Planning Inspectorate

Our Ref: EN0110012

Application by Light Valley Solar Limited for an order granting development consent for the Light Valley Solar project

The Examining Authority's response to a notification by the applicant of its intention to submit a request for changes to the application

LIGHT VALLEY SOLAR
Figure 12.07
Light Valley Solar - Site 6 & 7
Outline Environmental Masterplan -v3.0
[EN0110012/APP/LVS/02.12.07]

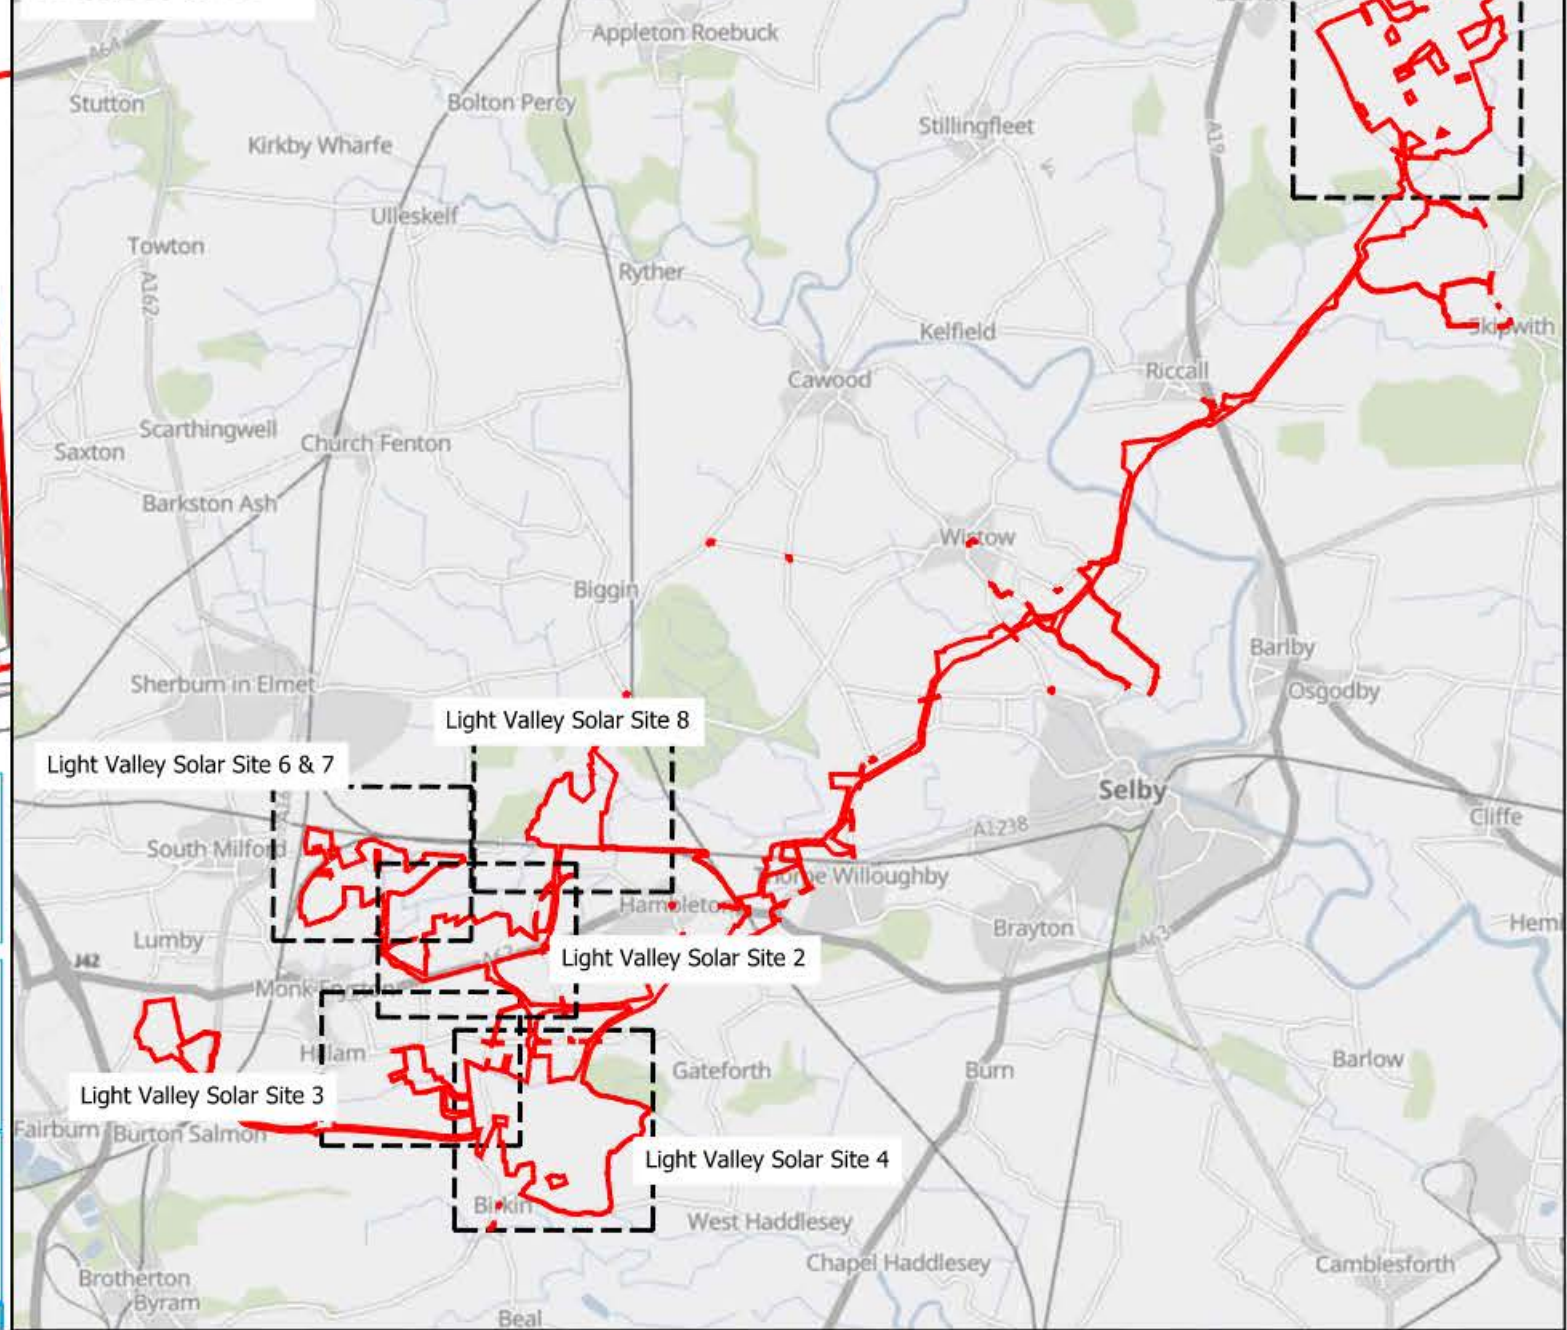
Change 7: The removal of an area of proposed solar panels at Solar Development Site 6 to the south of Milford Lodge and Milford Lodge Cottage to create a bird habitat area. No change to the Order limits is proposed.

- Information and evidence to justify the proposed bird habitat area (proposed Change 7), including its extent, dimensions, area and management objectives. The applicant should also identify whether the change would necessitate amendments to previously submitted visual assessment material, including viewpoints, zone of theoretical visibility mapping, landscape plans, photomontages or other representative visualisations, and provide updated material where necessary. Evidence and information should also be provided in the context of the previously identified data corruption issue, including how the proposal responds to concerns raised by North Yorkshire Council and the nature and outcome of discussions undertaken. The applicant should also clarify whether Natural England or any other relevant bodies have been consulted, and whether any consideration has been given to potential interactions with, or implications for, the proposed bird mitigation area at Solar Development Site 1. Given the applicant's stated position that the habitat area is not required to mitigate the impacts of the proposed development, the formal request should explain the basis on which its inclusion within the Order limits is necessary and justified, including the justification for any compulsory acquisition powers or rights sought over the land.
